Longmynd Consultants

Ref. LC/4737/01
23 August 2021

**The Mill, Clee St. Margaret, Craven Arms,
Shropshire, SY7 9DT**

title: **Proposed CORN MILL**

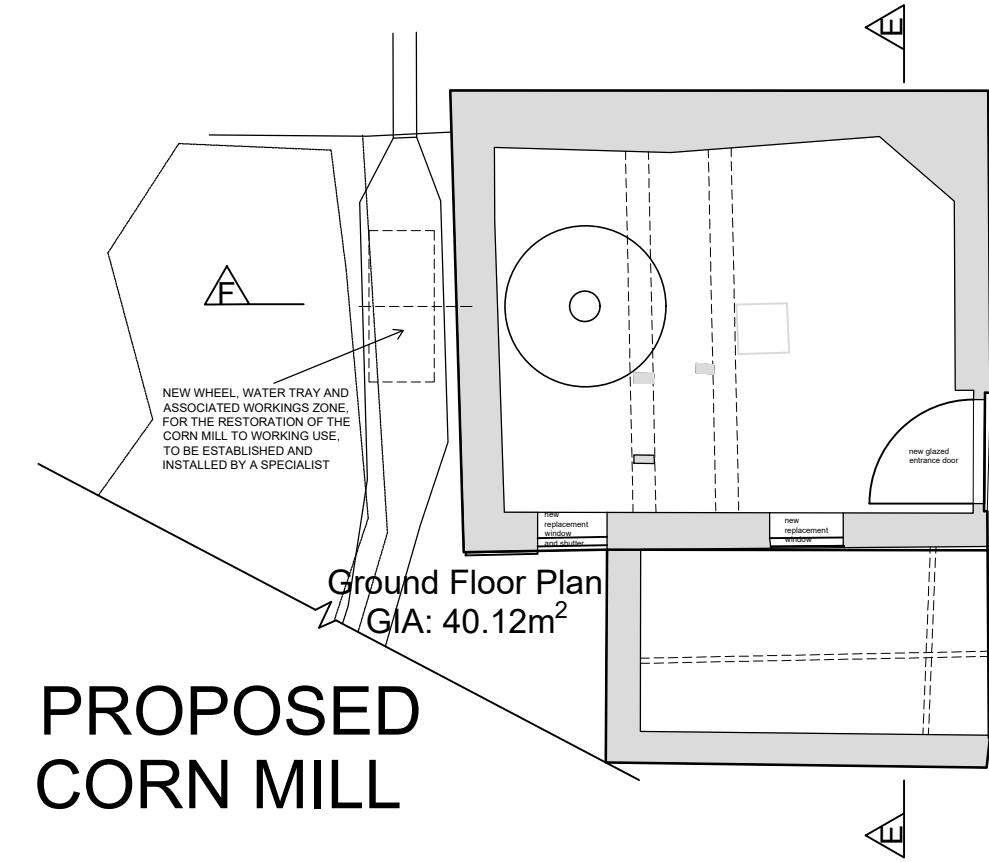
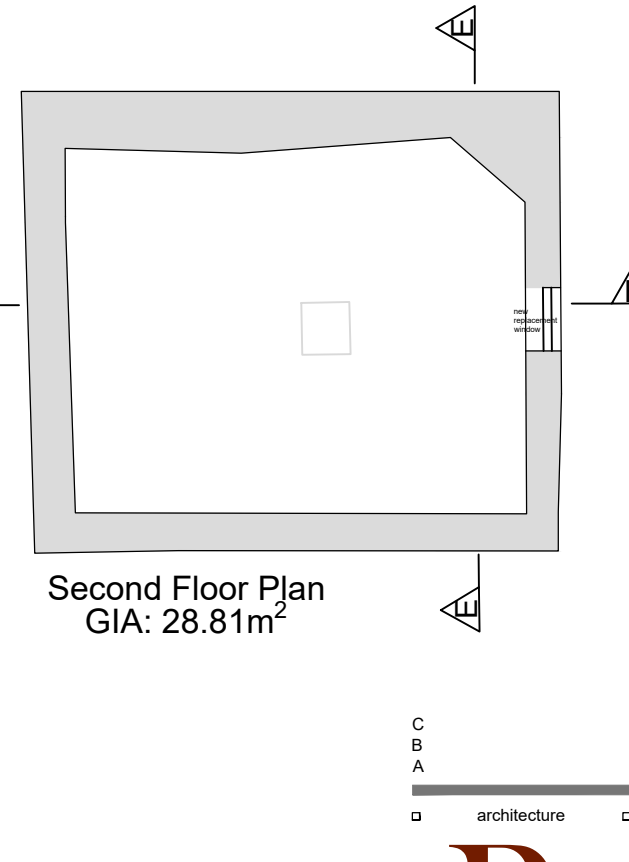
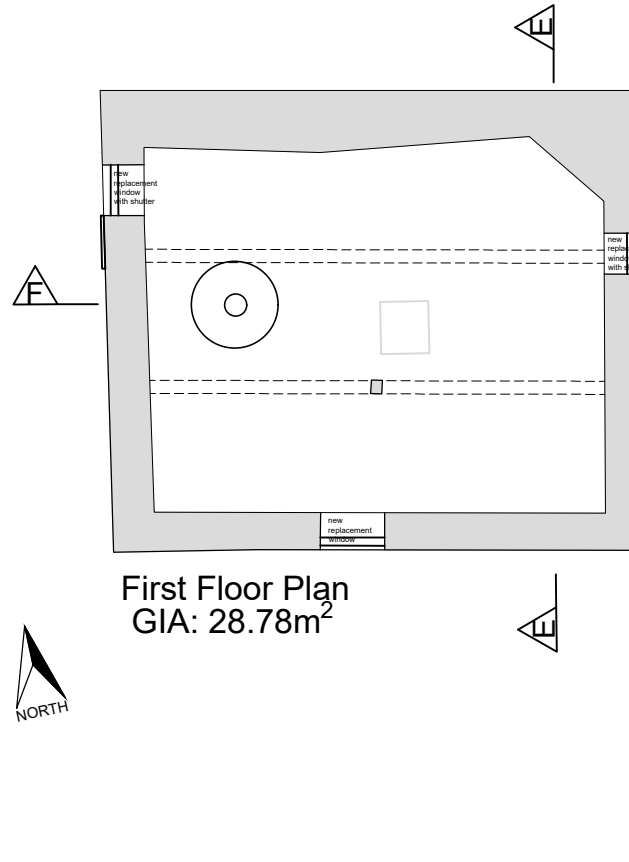
The tiled roof is in a very poor condition with excessive deflection of the roof planes, there are no gutters and plant growth has invaded to roof. I consider that the roof structure will require replacement in it's entirety to include, purlins, rafters and the single roof truss. The truss should be inspected at close quarters since it is possible that the original could be saved and strengthened. In view of the approaching winter and the possibility of further deterioration and possibly collapse I recommend that the roof replacement is made a priority.

The north flank wall has bowed in at ground floor level due to soil pressure and, whilst the wall movement cannot be corrected the pressure can be relieved and the wall propped. Accordingly I

recommend that the wall pressure is reduced as much as possible by excavating away the loose fill behind the wall. However it is important to note that excavation behind the wall should neither compromise the stability of the pond bund nor affect the reinstatement of the cast iron mill wheel feed pipe.

The side wall of the lean to structure has a dominant lean and it is recommended that the wall is reconstructed locally.

It is very important that the structure is safeguarded short term but that any measures introduced should be compatible with short term renovation works and long term structural stability. Assuming that the reinstatement of The Mill would mirror the existing flooring and mechanical parts then I would recommend that steel ring beams are inserted at floor levels thus providing buttressing support for the walls and also a bearing wall plate for the future floors. At this stage I would expect that these beams could be 150 x 90 PFC's (Parallel flange channel) with 152 x 152 UC cross beams and corner diagonal strengtheners. The PFC's would be connected to the stonework walls with 12 diameter resin anchors at 600 cc. Packers between the PFC's and the stonework will be required to take up unevenness. In view of the potential floor loadings posts against the walls should be allowed for to support the majority of the vertical loads.

The ground floor should be replaced with 175 mm concrete slab reinforced with A393 fabric top and bottom, this will give a flat and dry working floor but also provide foundation for any raking struts found necessary. The slab would have 275 deep edge thickenings which would support any posts. The slab would be cast onto 100 mm of well compacted hardcore between edge thickenings.

It is important that the existing wall foundations are investigated in order to provide parameters to justify existing foundations but also to provide the basis for the structural ground floor slab.
